EPC STORMWATER REVIEW COMMENTS
IN ORANGE BOXES WITH BLACK TEXT

GRANDWOOD RANCH

ROAD AND STORM PLANS

<h1>GRANDWOOD RANCH</h1>				
<h2>EL PASO COUNTY - SF 2026 ROAD AND STORM PLANS</h2>				
<h3>ROADWAY PLAN</h3>				
DESIGNED BY:	CAP	SCALE	DATE ISSUED:	DECEMBER 2020
DRAWN BY:	CAP	HORIZ 1" = 40'		
CHECKED BY:	NMS	VERT. N/A	SHEET	6 OF 40
				DRAWING No. RD01

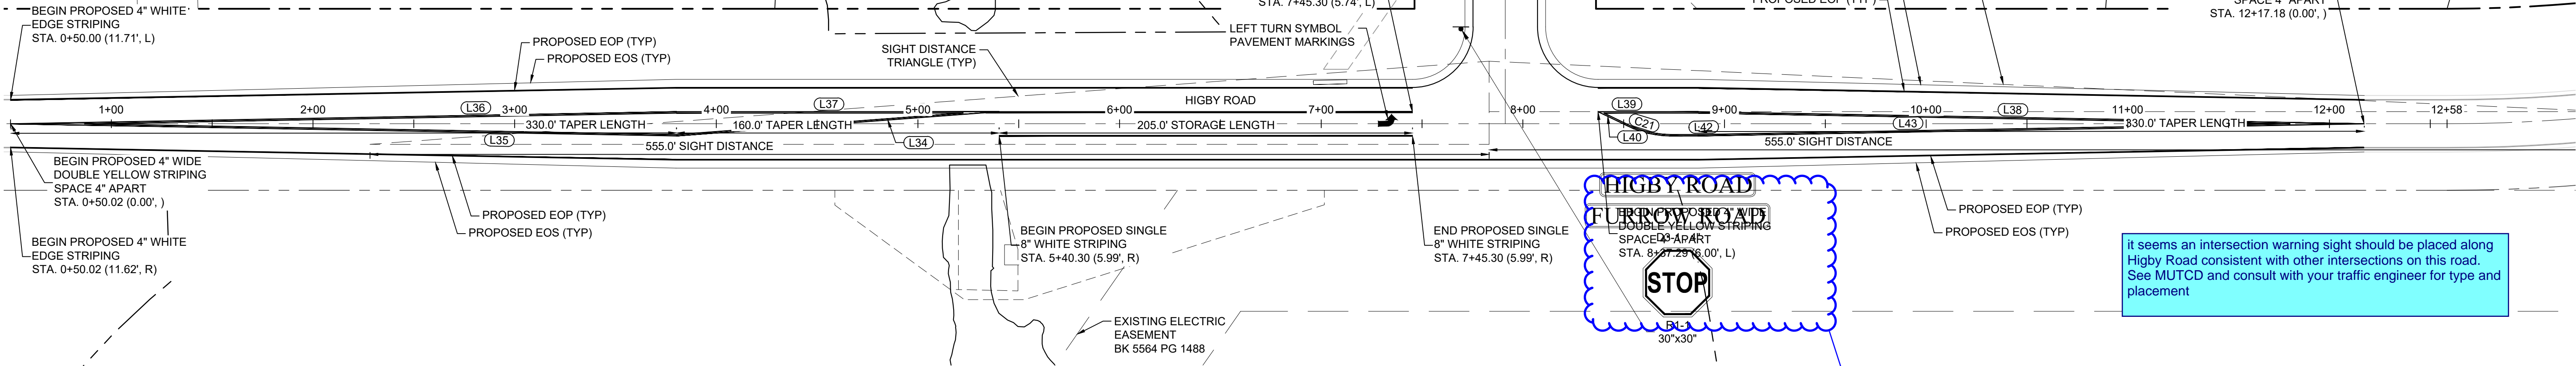
Please provide line of sight and sight distance should be marked on plans. Per ECM 2.3.7.C.5

The sight distance at intersections shall be shown geographically on the construction plans. A note shall be added to each leg of the intersection stating that intersection sight distance exceeds the minimum sight distance for ____ mph design speed.

Sight distance lines have been added to the signage and striping plans (added to this set)

HIGBY ROAD SIGNAGE & STRIPING

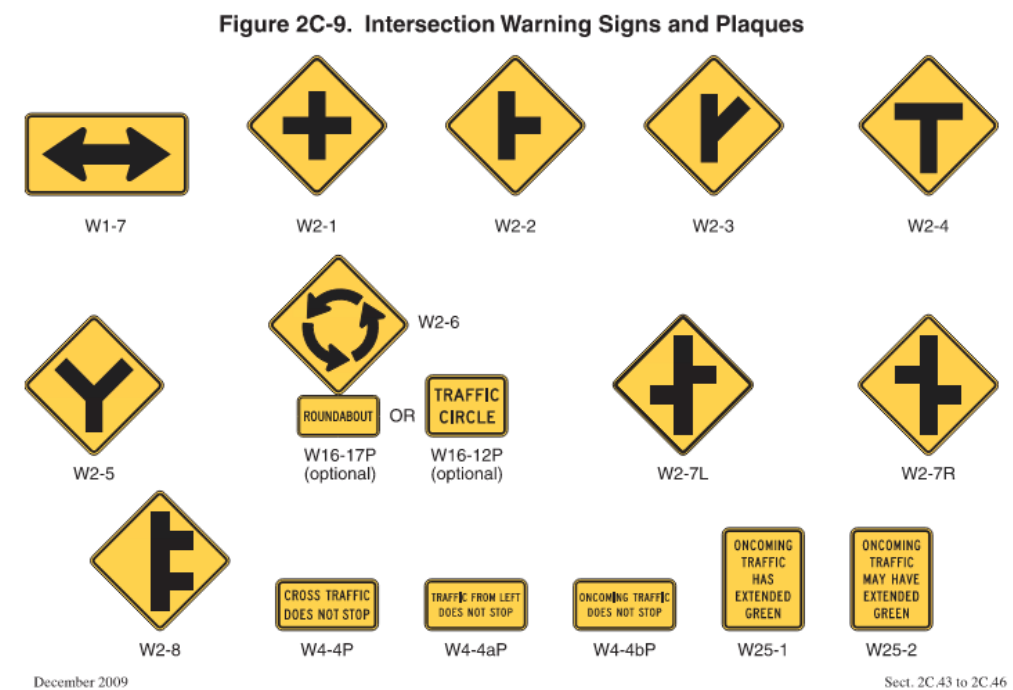
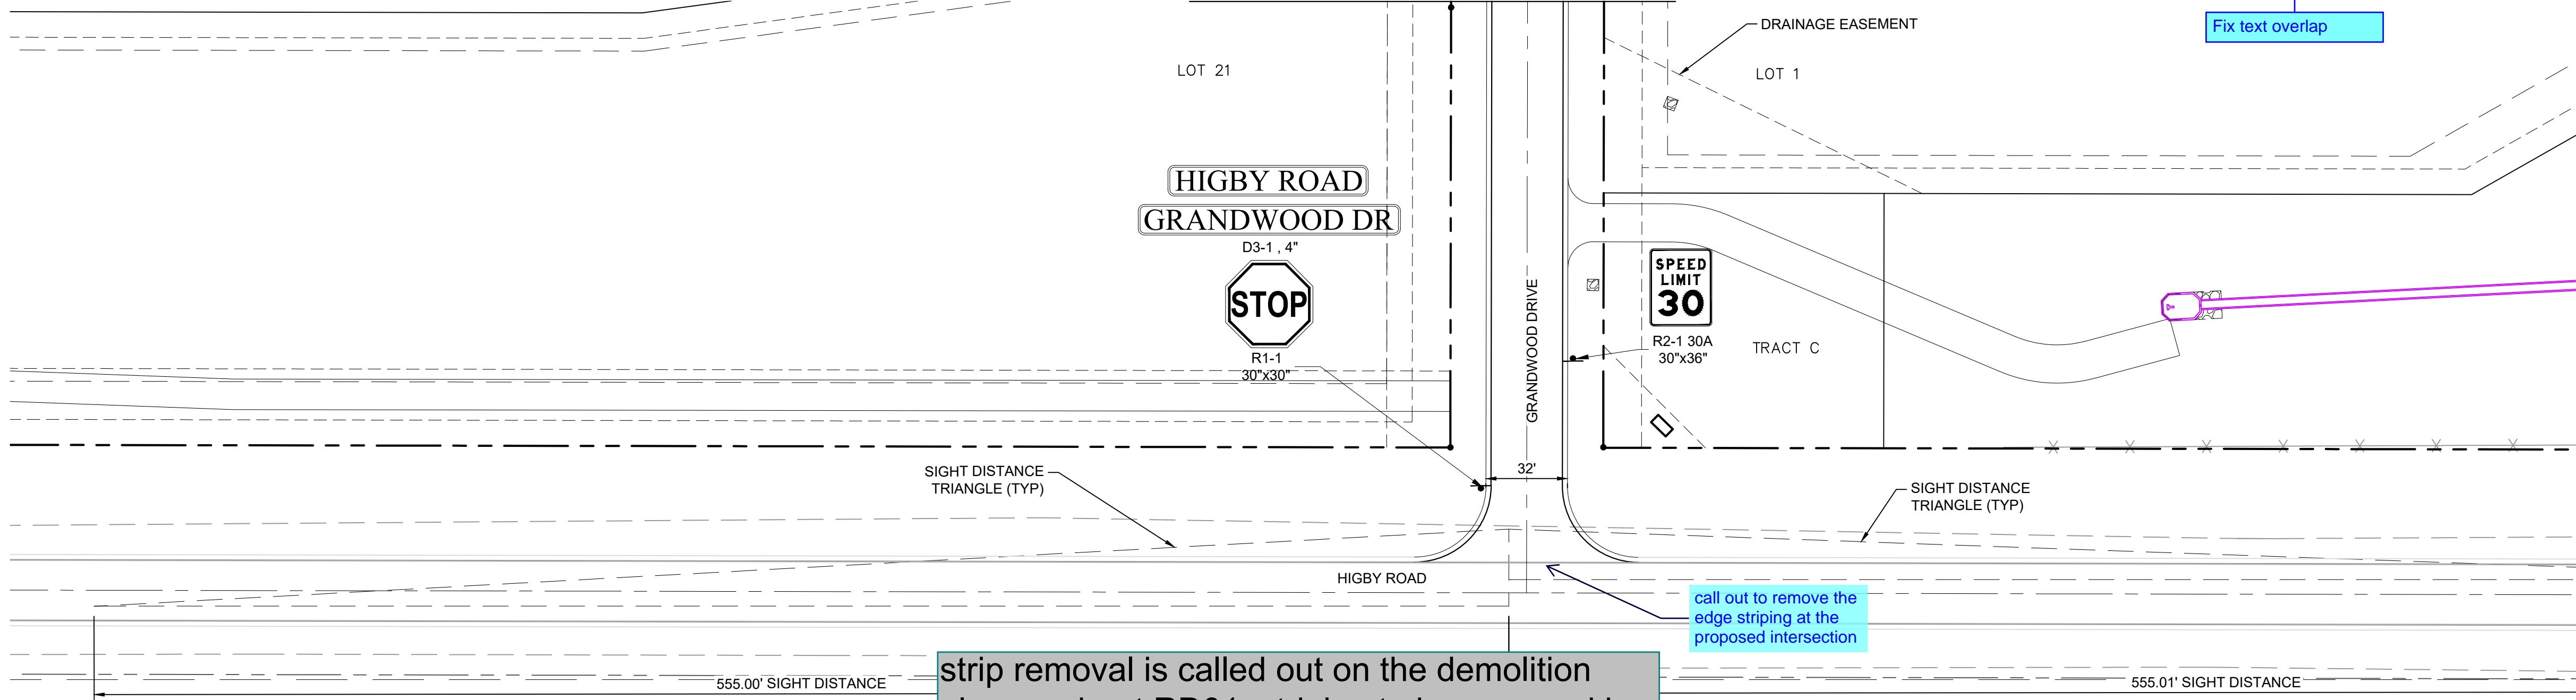
2. LANE LINES
- Specify yellow striping width and spacing between the double yellow. See snippet above from the CDOT M&S standards

Missing pavement markings for left turn lane. Revise to include relevant markings per CDOT M&S Standards section.

Revise all pavement markings per CDOT MS standards, pavement markings.
